<b>Environmental Health Consultation Response</b>	<b>Officer</b>	<b>Alan Taylor</b>
---	----------------	--------------------

**Detail: Planning request 3/2017/1223**

<b>Address:</b>	<b>Chipping Lane Chaigley BB7 3LX</b>			 <b>Ribble Valley Borough Council</b> <a href="http://www.ribblevalley.gov.uk">www.ribblevalley.gov.uk</a>
<b>Application Ref:</b>	SRU 38273	<b>Case Officer:</b>	Robert Major	
<b>Response Ref:</b>	/ENV/01	<b>Issue Date:</b>	30 January 2018

Drawing file: planx_downloads / 17_1223_Amended_plans_250118.pdf

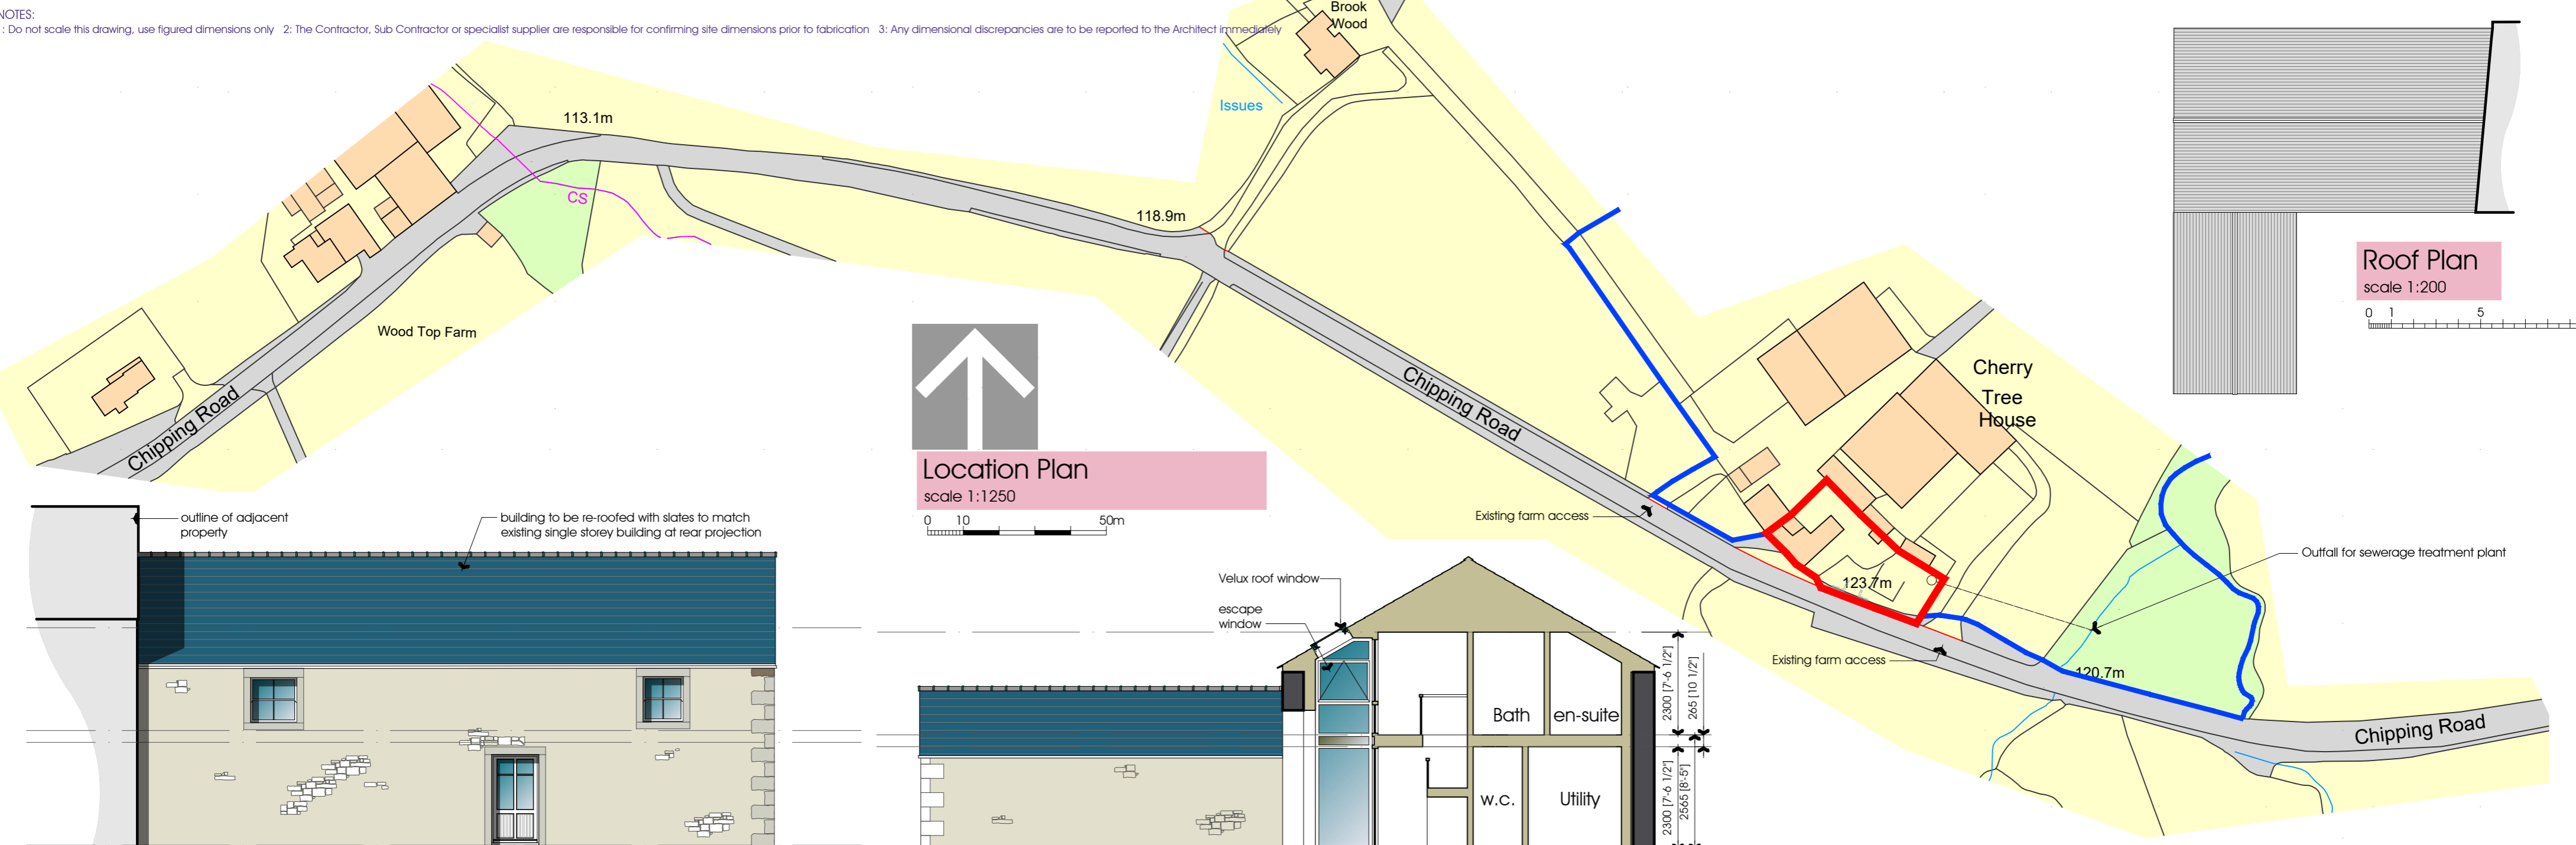
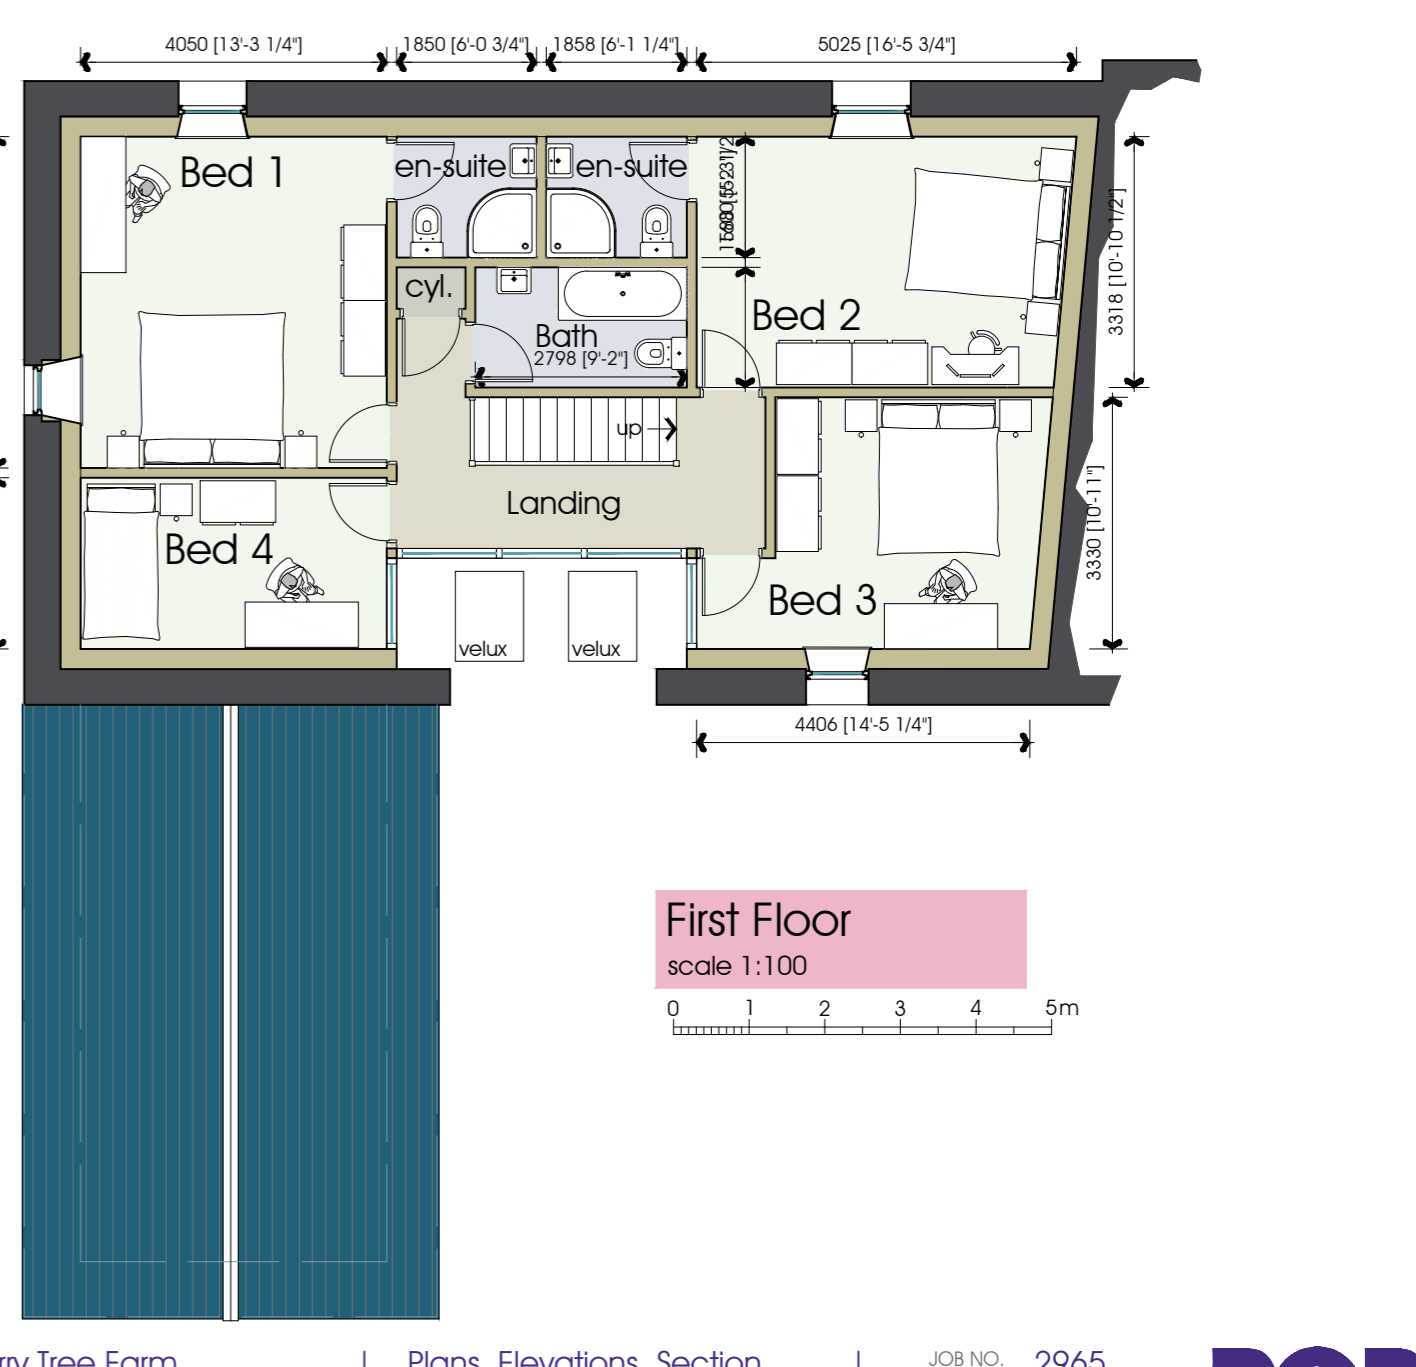
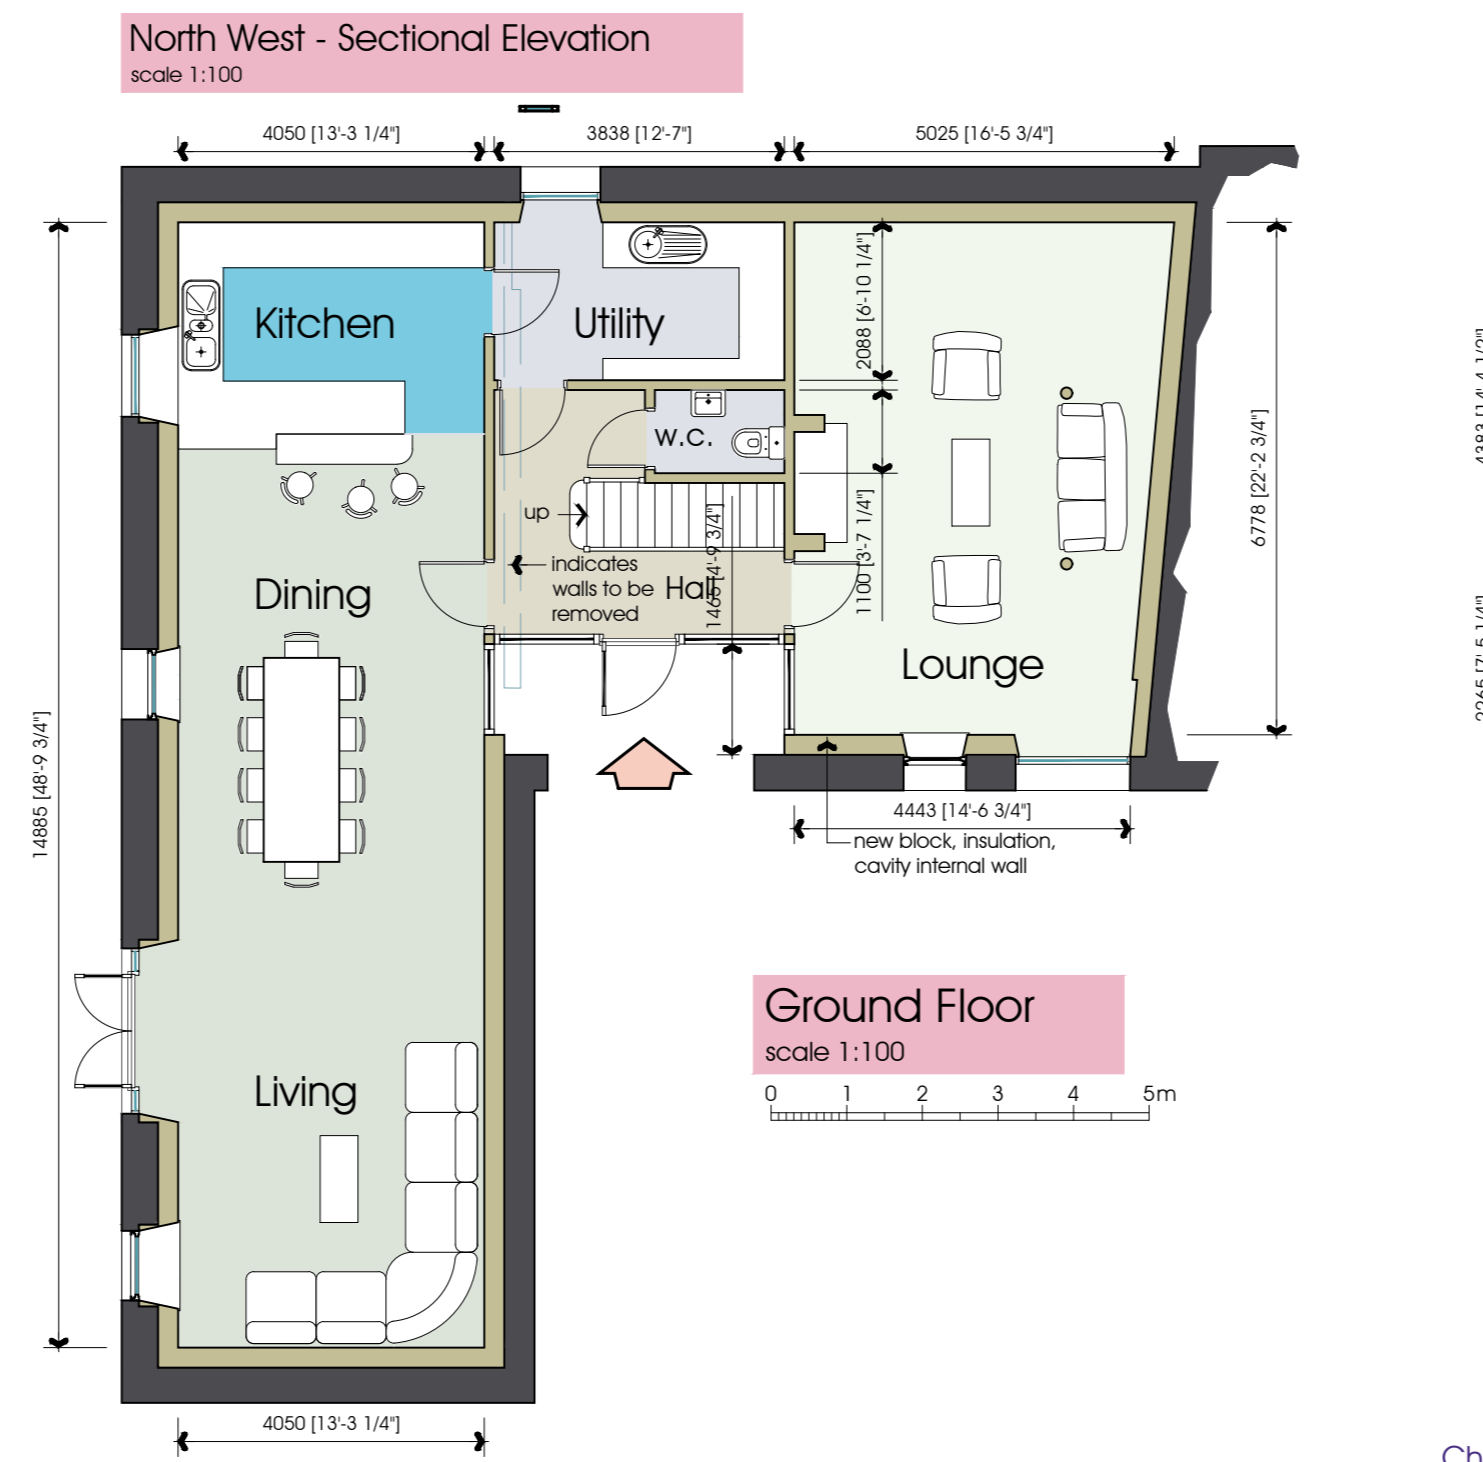
<b>General Comments/Observations</b>	
<b>1.1</b>	The planning application is for the conversion of an agricultural barn to a private residential dwelling
<b>Suggestions/Mitigation</b>	
<b>2.1</b>	At the time of the original application, the sewage treatment was unknown. The updated plan indicates the sewage treatment will outlet next to a natural water course. The applicant will have to contact the Environment Agency with the update plan for sewage treatment and outlet.
<b>2.2</b>	If a private water supply is used to service the property then condition the treatment of the private supply to the property.
<b>Conclusions/Suggested Conditions</b>	
<b>2.3</b>	The above observations have been provided on the basis of the level of information submitted and the comments contained within this response represent officer opinion only, at the time of writing, without prejudice.
<b>2.4</b>	Should you be minded to approve the application, notwithstanding other considerations, I would suggest that the following conditions be attached should you feel they are relevant and justified: <ul style="list-style-type: none"> <li>• The applicant needs to contact the Environment Agency to inform of how the sewage will be treated and where they propose to drain the treated sewage to?</li> <li>• This property is serviced by an unchlorinated private water supply. A suitable water treatment plant must be installed to ensure the quality of the water complies with the requirements of the Private Water Supply Regulations 2016</li> </ul>
